Lime Down Solar Park – Development Consent Order (DCO) Application

Environment Agency Examination Deadline 2 Response: Comments on documents submitted at Deadline 1

Title:
Figure 11.5 Rev 4: Lime Down D (BESS)
Fluvial and Surface Water Flood Risk Map

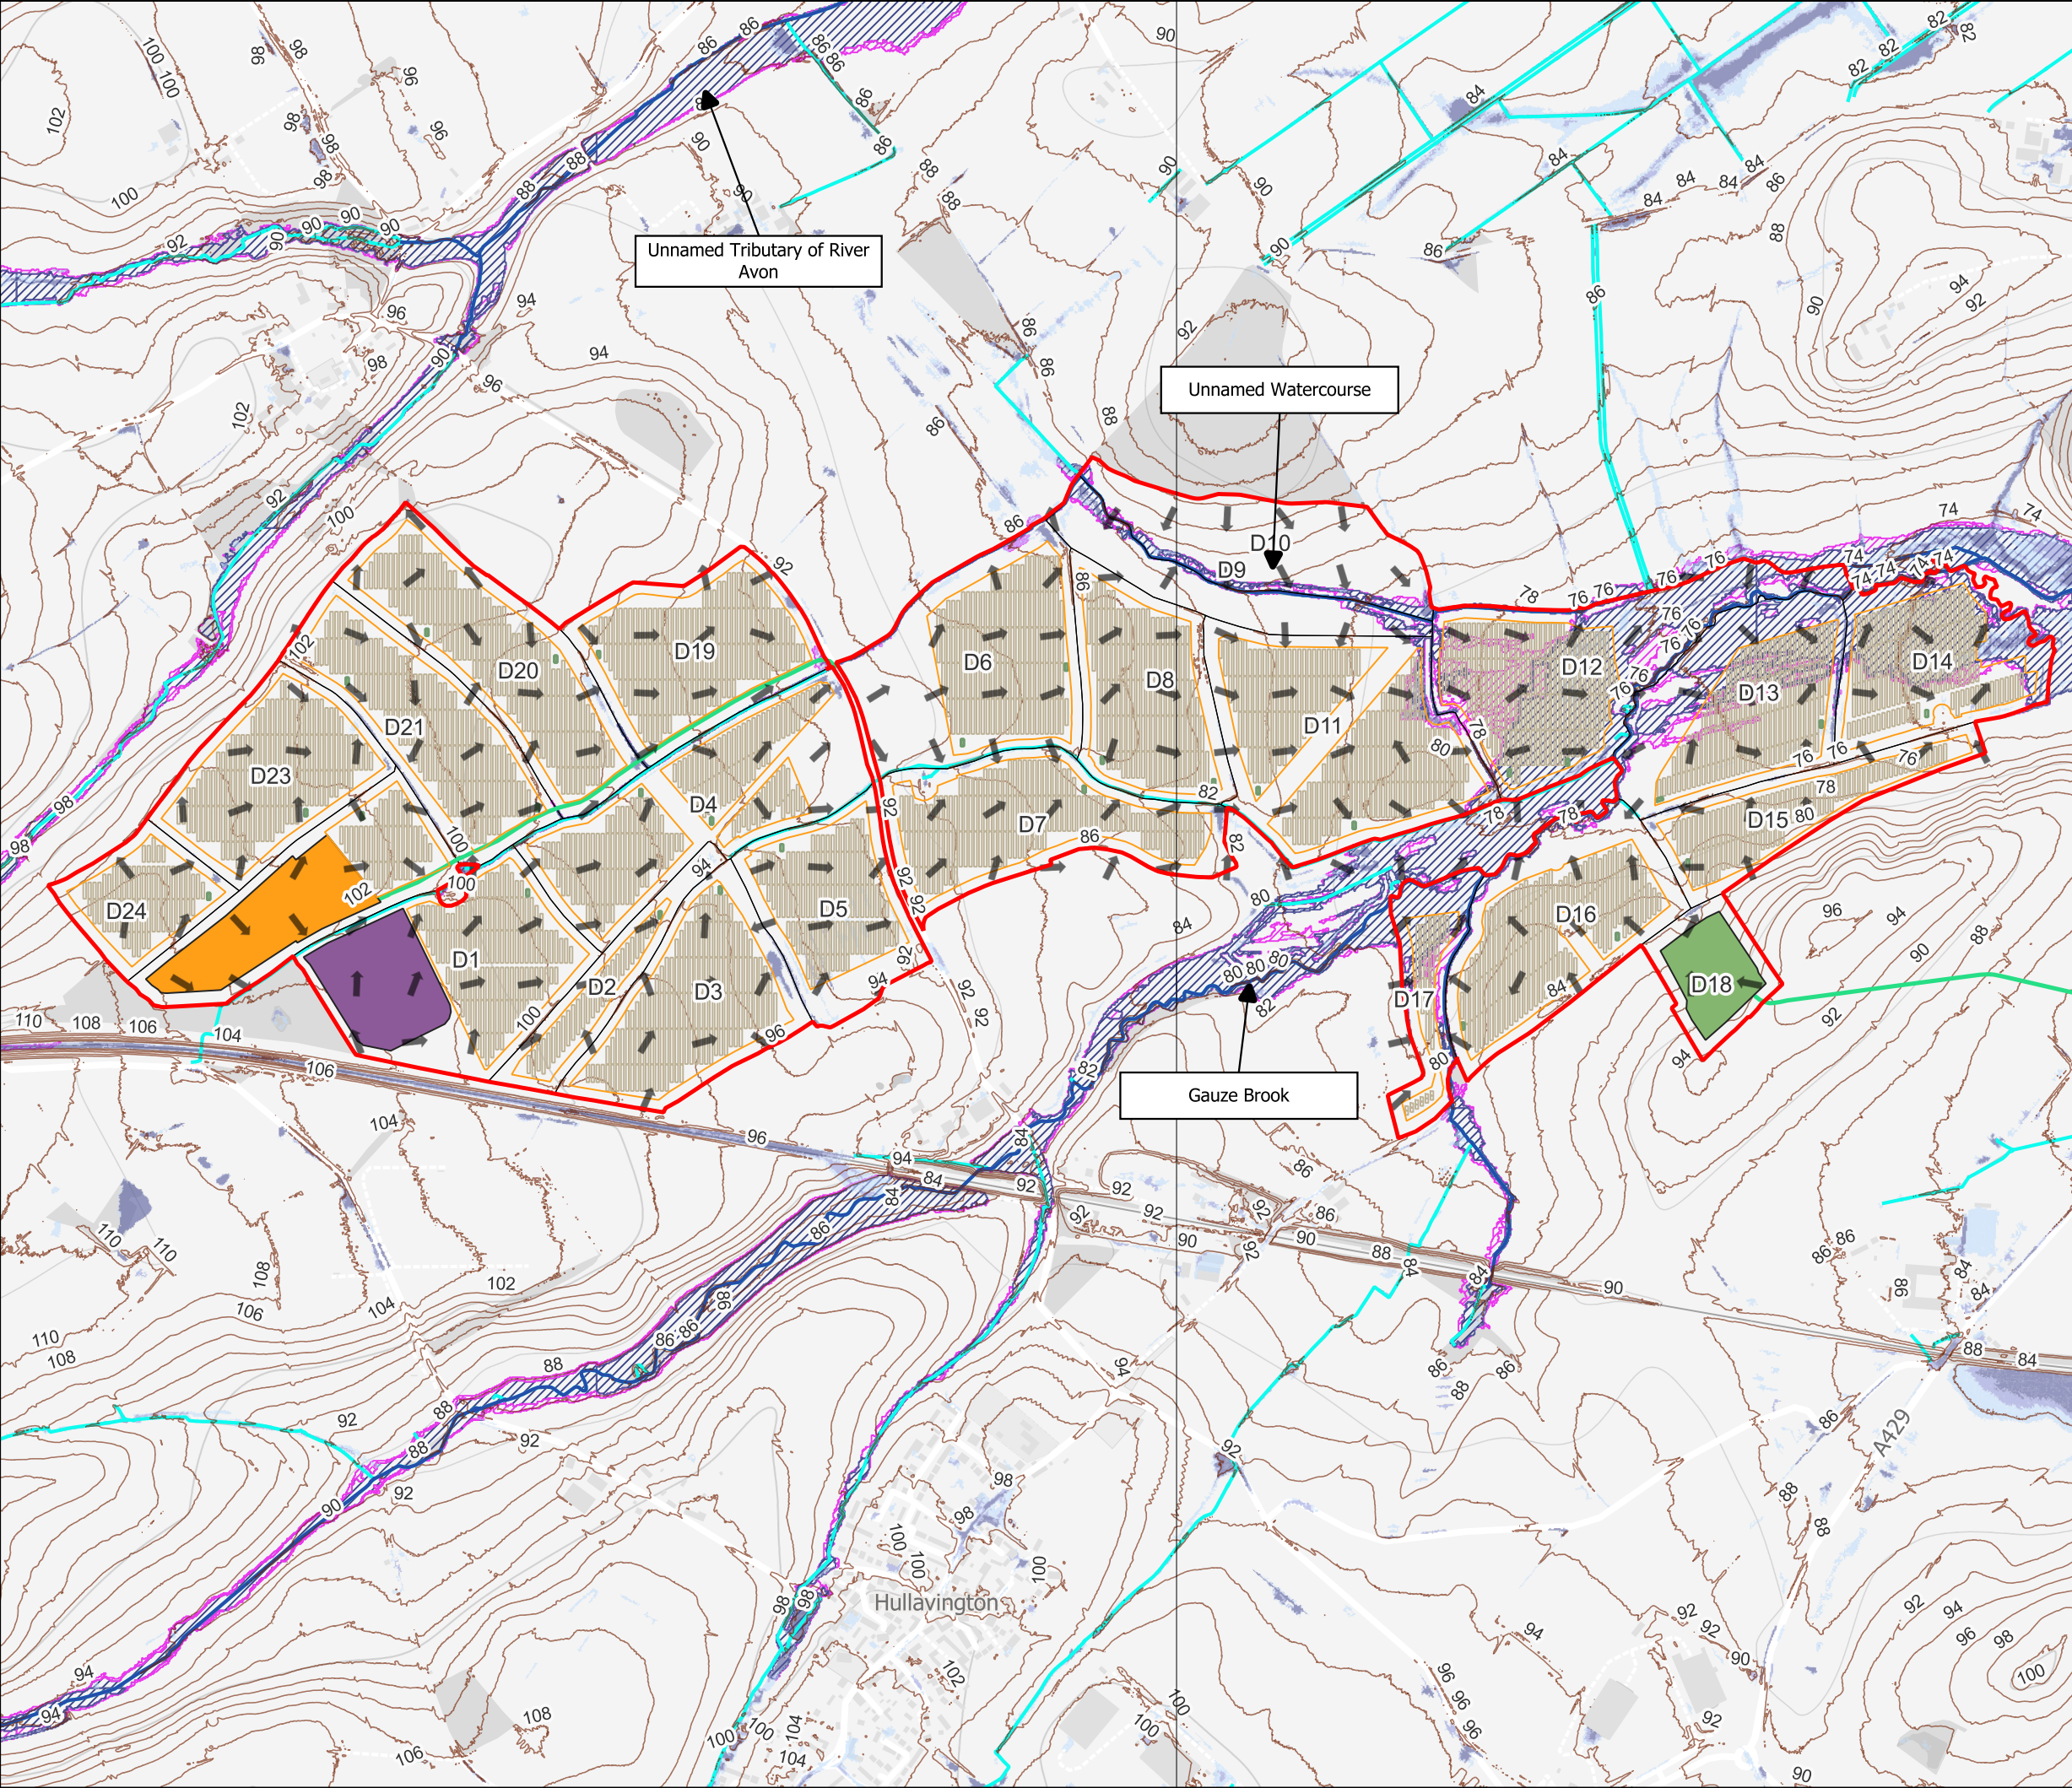
EA RR ID Ref in PDA-009	Issue	Topic (s)	EA Position at Deadline 2
			isolation system might not be in use during normal operation, we expect an acknowledgement in this table that one will be present.
EA-049	Flood Risk Assessment	Functional Floodplain (Flood Zone 3b).	<p>Under Discussion</p> <p>It appears some of the solar PV panel supports are within areas of functional floodplain within Lime Down D and Lime Down E2. In revision 2 (May 2026) of the updated Flood Risk Assessment and Drainage Strategy the applicant describes how the panelled areas are not expected to give rise to a material loss of floodplain storage or material obstruction of flood flow routes. This seems reasonable based on the volumetric calculations and associated level estimates provided for Lime Down D and Lime Down E2. We note that the applicant has undertaken further modelling for Lime Down E2 and will delineate Flood Zone 3b based on this modelling. We await this information before taking a final view on this matter.</p>

EA-050	Flood Risk Assessment	Fencing must not inhibit flood flow routes.	<p>Under Discussion</p> <p>Section 2.3.15 page 17 within the updated REP1-048 6.3 ES Volume 3 Appendix 11-6 Flood Risk Assessment and Drainage Strategy Lime Down D (Rev 2) notes that any fencing within areas of flood interaction will be permeable to both water and debris passage and will not impede flood flow routes. This is welcomed although we would ask that more specificity is provided. Please can the applicant provide details on the type of fencing that will be used in terms of mesh spacing and how blockage risk will be managed. Mesh spacing should be as wide as possible to reduce blockage risk. There should be a commitment within the Operational</p>

EA RR ID Ref in PDA-009	Issue	Topic (s)	EA Position at Deadline 2
			Environmental Management Plan to ensure any debris is removed from fencing following floods.
EA-051	Flood Risk Assessment	No assessment of the impacts the construction phase of the development will have on flood risk.	Under Discussion The applicant needs to undertake additional assessment of the impact the construction phase may have on the floodplain capacity and flow routes. Additionally, additional mitigation commitments may needed. For example, there should be no storing of materials and/or construction compounds within flood zone 3b and where practicable outside of the 1 in 100 year extent.
EA-052	Flood Risk Assessment	It is not clear what freeboard allowances are proposed.	Under Discussion Within the updated Flood Risk Assessment and Drainage Strategy REP1-048 6.3 ES Volume 3 Appendix 11-6 Flood Risk Assessment and Drainage Strategy Lime Down D (Rev 2) and REP1-052 6.3 ES Volume 3 Appendix 11-8 Flood Risk Assessment and Drainage Strategy Lime Down E2 (Rev 2)(May 2026) paragraph 2.3.8 notes that electrical infrastructure including inverter, transformers, and substation, will either be located outside of modelled flood extents or raised above a minimum freeboard of 0.6 metres above the design flood level. This is welcomed, however, there doesn't appear to be a value assigned to the freeboard applied above the design flood level for the solar PV panels. For Lime Down E, paragraph 2.3.13 states that these will be above the design flood level with an appropriate freeboard allowance. Paragraph 2.3.13 within the Flood Risk Assessment for Lime Down D/BESS states that for both fixed and tracker

EA RR ID Ref in PDA-009	Issue	Topic (s)	EA Position at Deadline 2
			<p>panels all sensitive electrical equipment mounted on the Solar PV Panels will be elevated so that there is not less than 0.6 metres of freeboard above the design flood level. For clarity, the applicant should confirm what the freeboard will be to the lowest leading edge of the respective solar panels. The applicant should make a commitment to ensure there is a 0.6 metre freeboard above the design flood level for the solar panels themselves. If a freeboard of less than 0.6 metres is being adopted for the Solar PV panels, then the applicant should provide clear justification as to why this is reasonable and clarify what the minimum freeboard will be.</p>
EA-053	Flood Risk Assessment	Hydraulic model files for the Gauze Brook have not been reviewed.	<p>Under Discussion The applicant has now provided the model files and we are reviewing them.</p>
